RE: **S6/2015/0524/FP - Woodfield (Blue Moon), Woodfield Lane, Brookmans Park**

In the absence of an acceptable FRA we object to the grant of planning permission and recommend refusal on this basis for the following reasons:

The FRA carried out by ARK Environmental Consultancy Ltd dated 29 April 2015 submitted with this application does not comply with the requirements set out in the Planning Practice Guide (as revised 6 April 2015) to the National Planning Policy Framework. The submitted FRA does not therefore; provide a suitable basis for assessment to be made of the flood risks arising from the proposed development.

Drawing No.
P/309

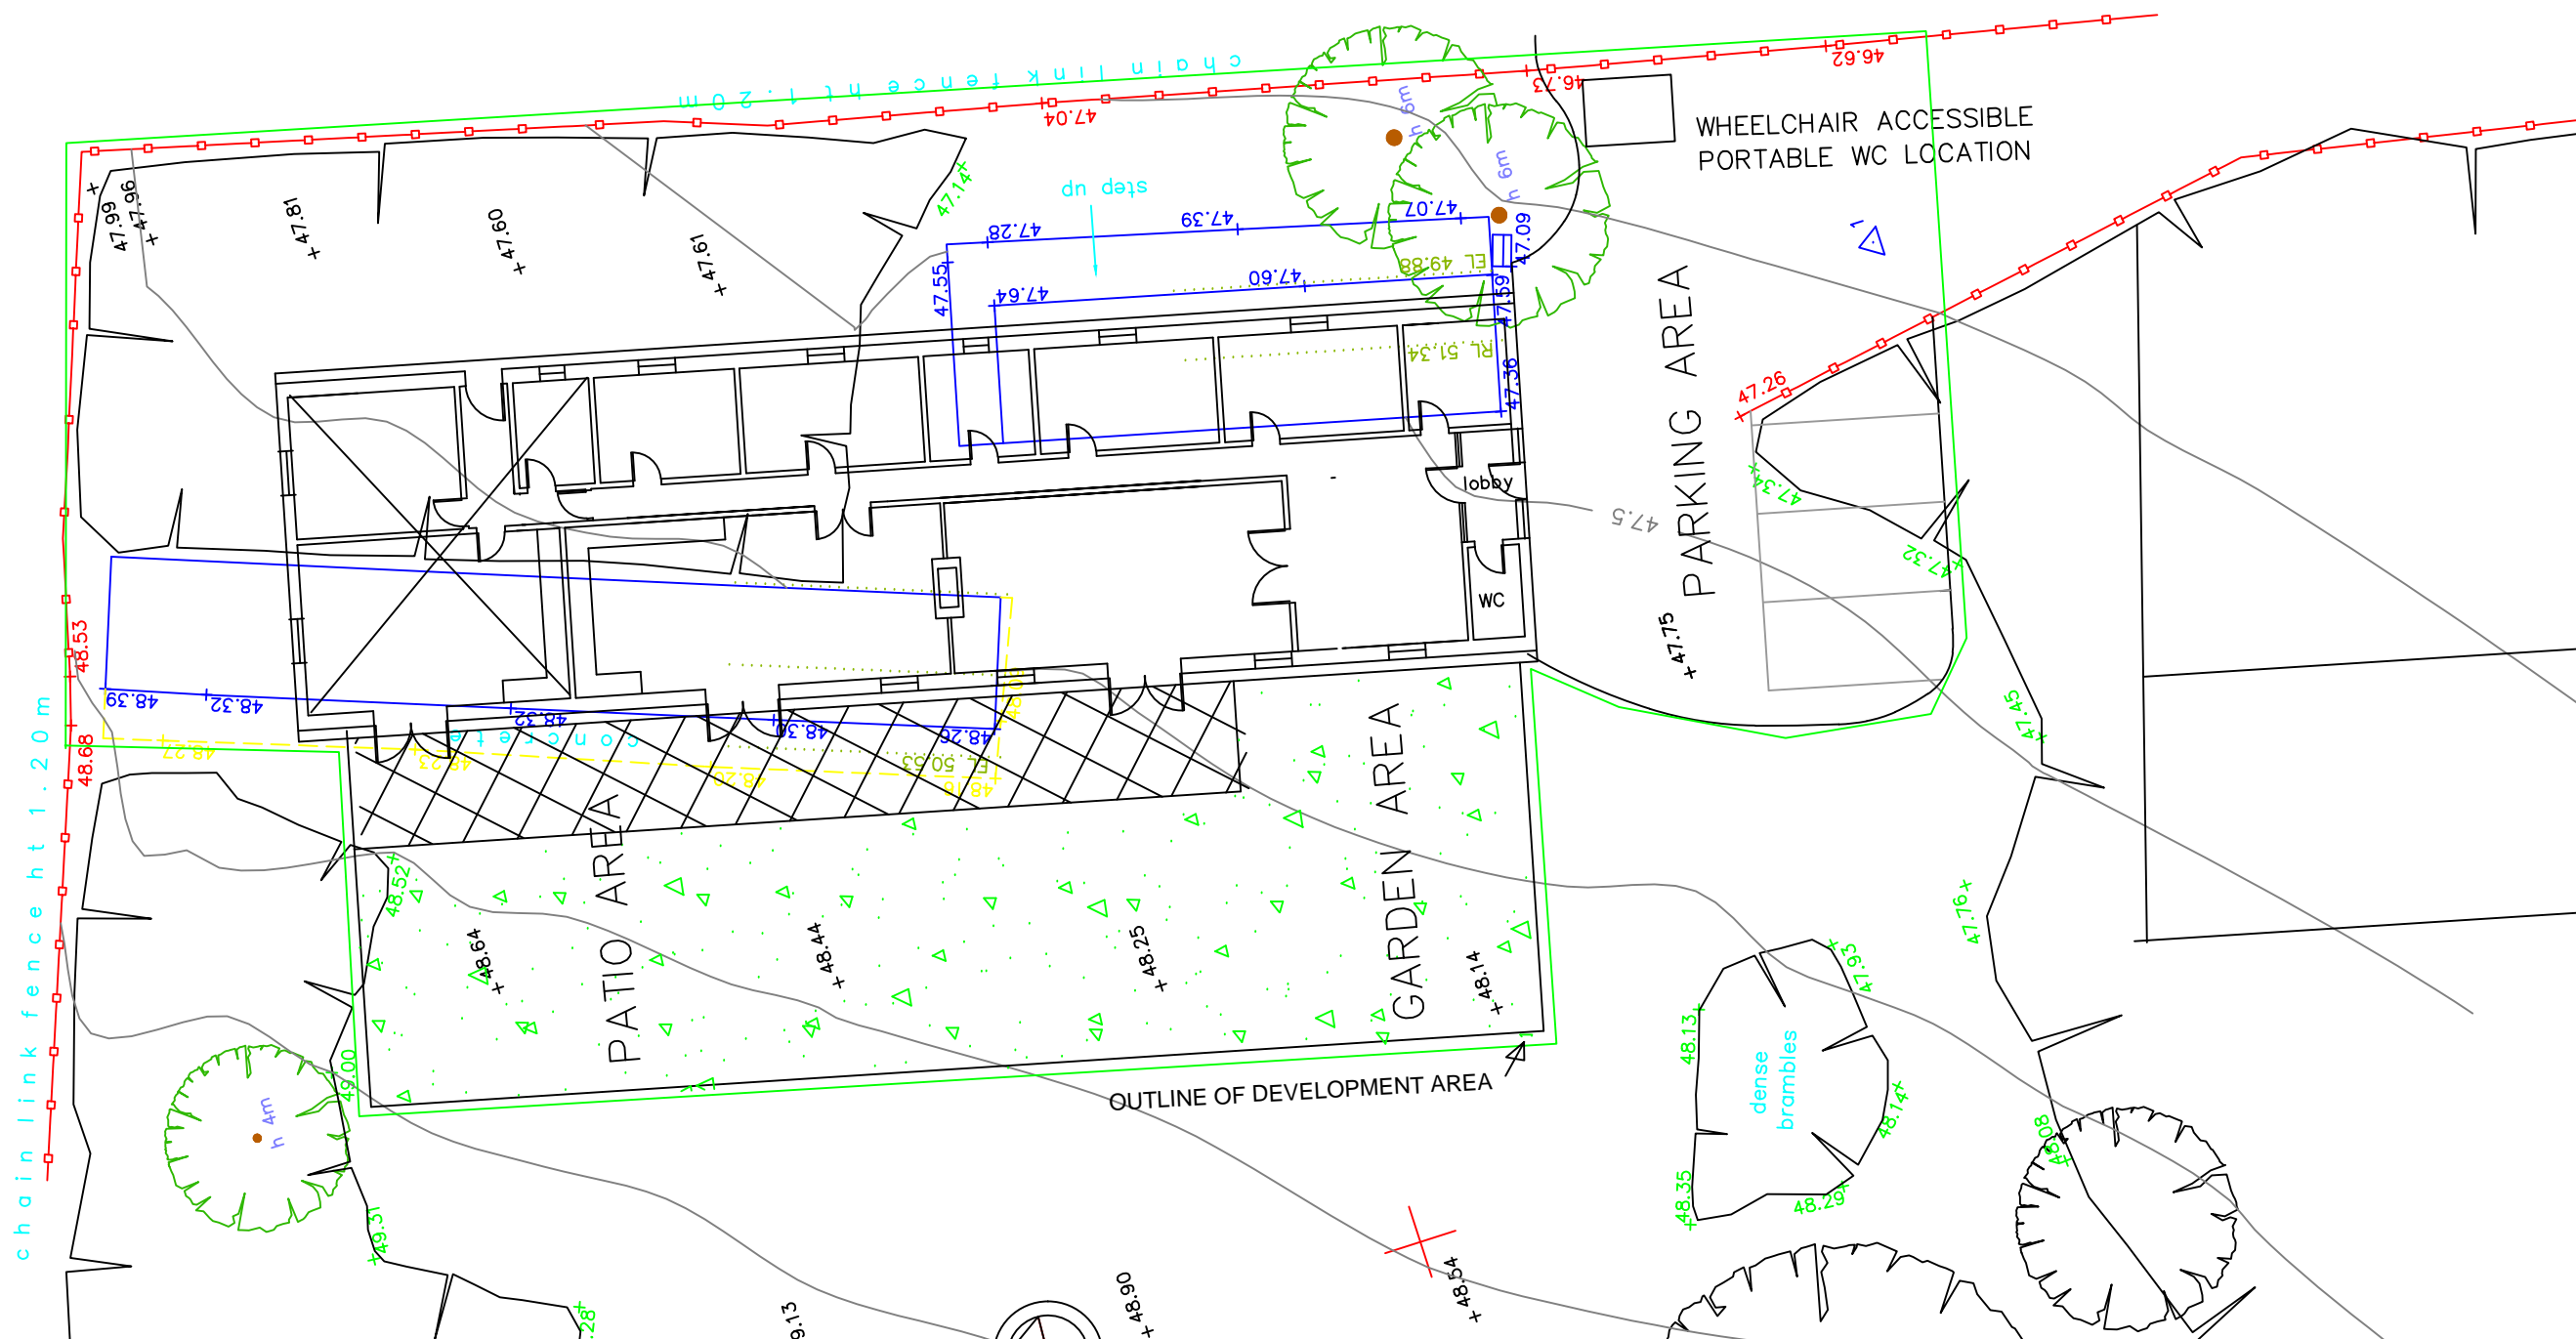
The FRA should ensure that the proposed location of the proposed residential home is appropriate as it is proposed to locate the property on one of the lowest parts of the site with the land sloping from west to east towards the property. The FRA should assess and demonstrate that there is no risk from existing overland flow routes and is able to provide appropriate flood resilience and mitigation against this risk, including considering an alternative location within the site.

As this is for a new development, formal drainage will need to be provided to drain the property. Therefore it is important that the proposed and existing greenfield run-off rates are assessed and appropriate SuDS can be implemented to cater for any increase in rates and volumes and provide other benefits such as water quality, biodiversity and amenity. The proposed drainage should be provided on a plan showing the location of any SuDS measures and pipe runs.

It is stated within the FRA that it is intended to discharge the surface water to the existing land. We assume this is through the method of infiltration, however no infiltration tests in accordance with BRE 365 have been provided to demonstrate that this is feasible. If infiltration tests cannot be provided, an alternative scheme should be demonstrated based on above ground attenuation with an appropriate discharge point to the nearest watercourse or if not feasible to the nearest public sewer with confirmation of permission to connect to the sewer from the relevant water authority.
